# Elevations\_v1-redline.pdf Markup Summary

BUILDING 4

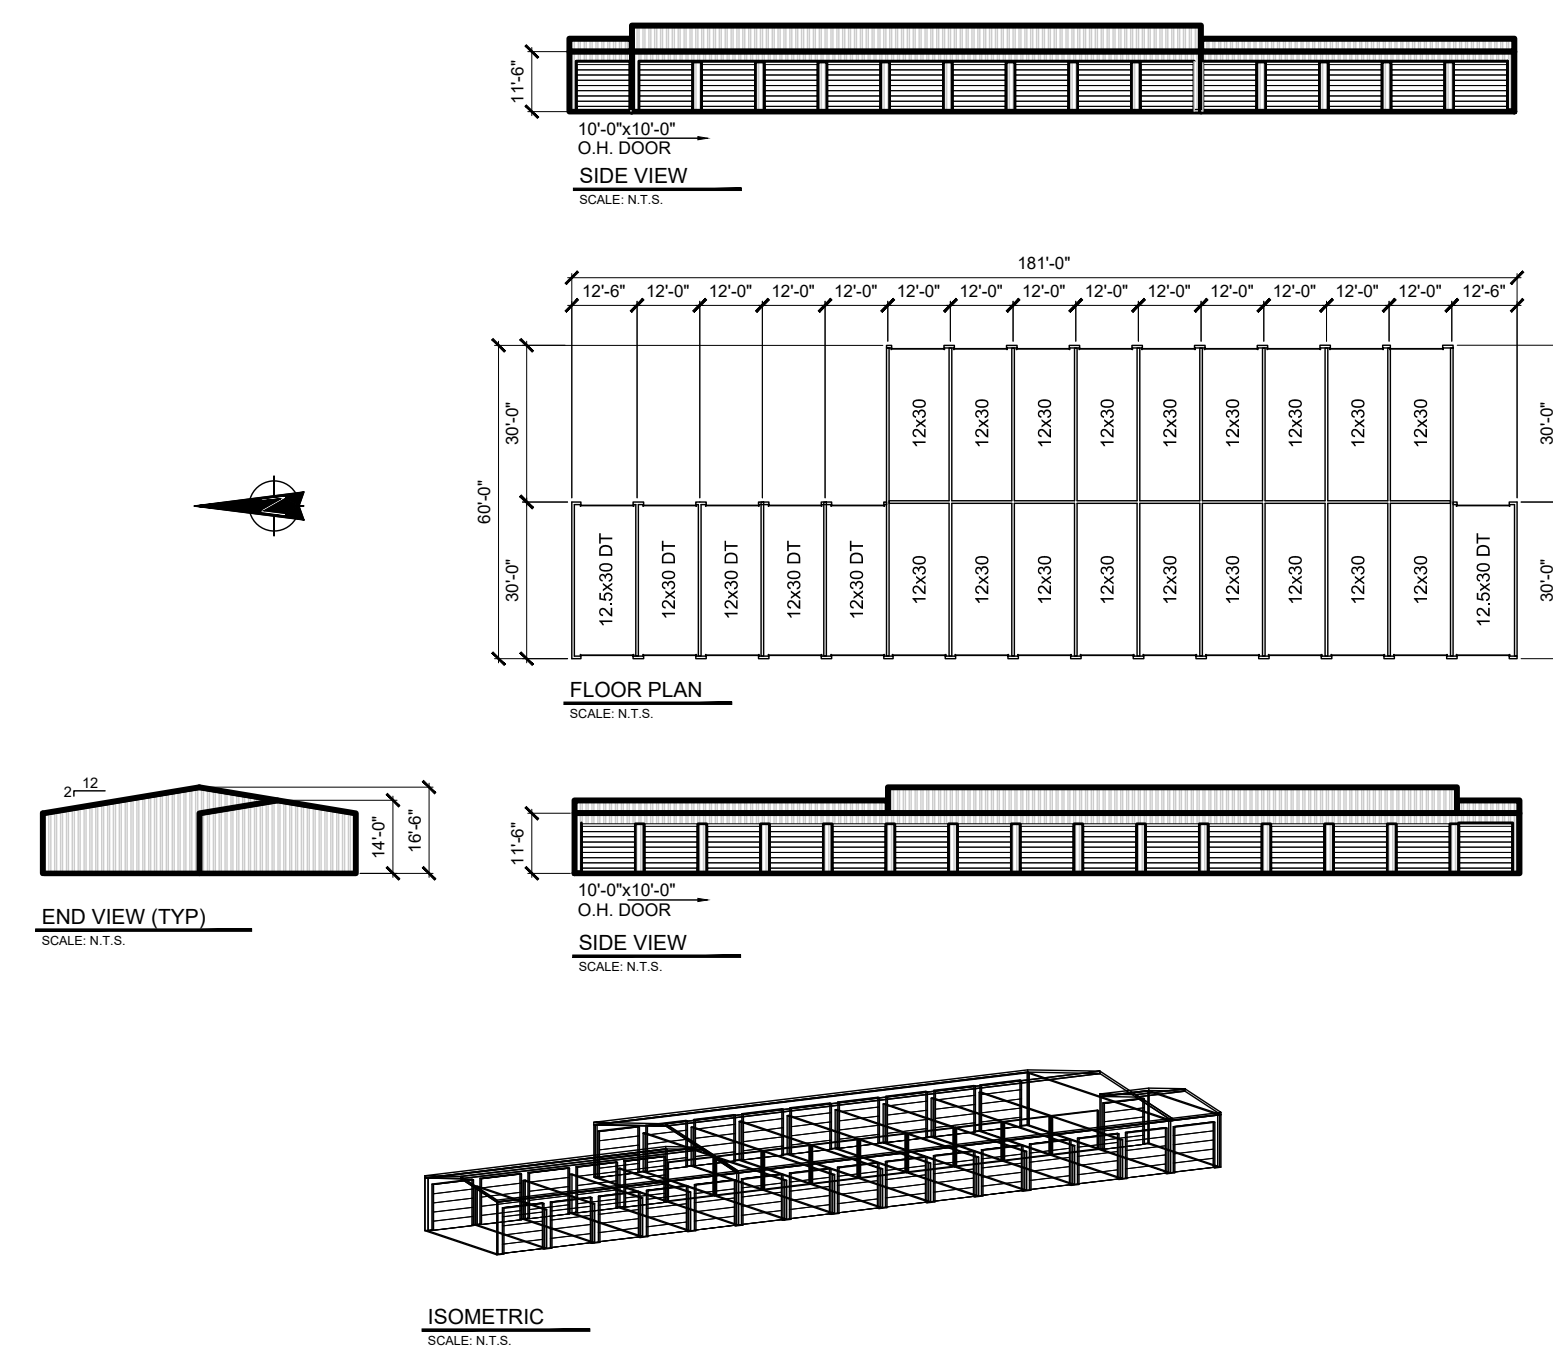
Show heights of structures (1)

Show heights of structures

Show heights of structures
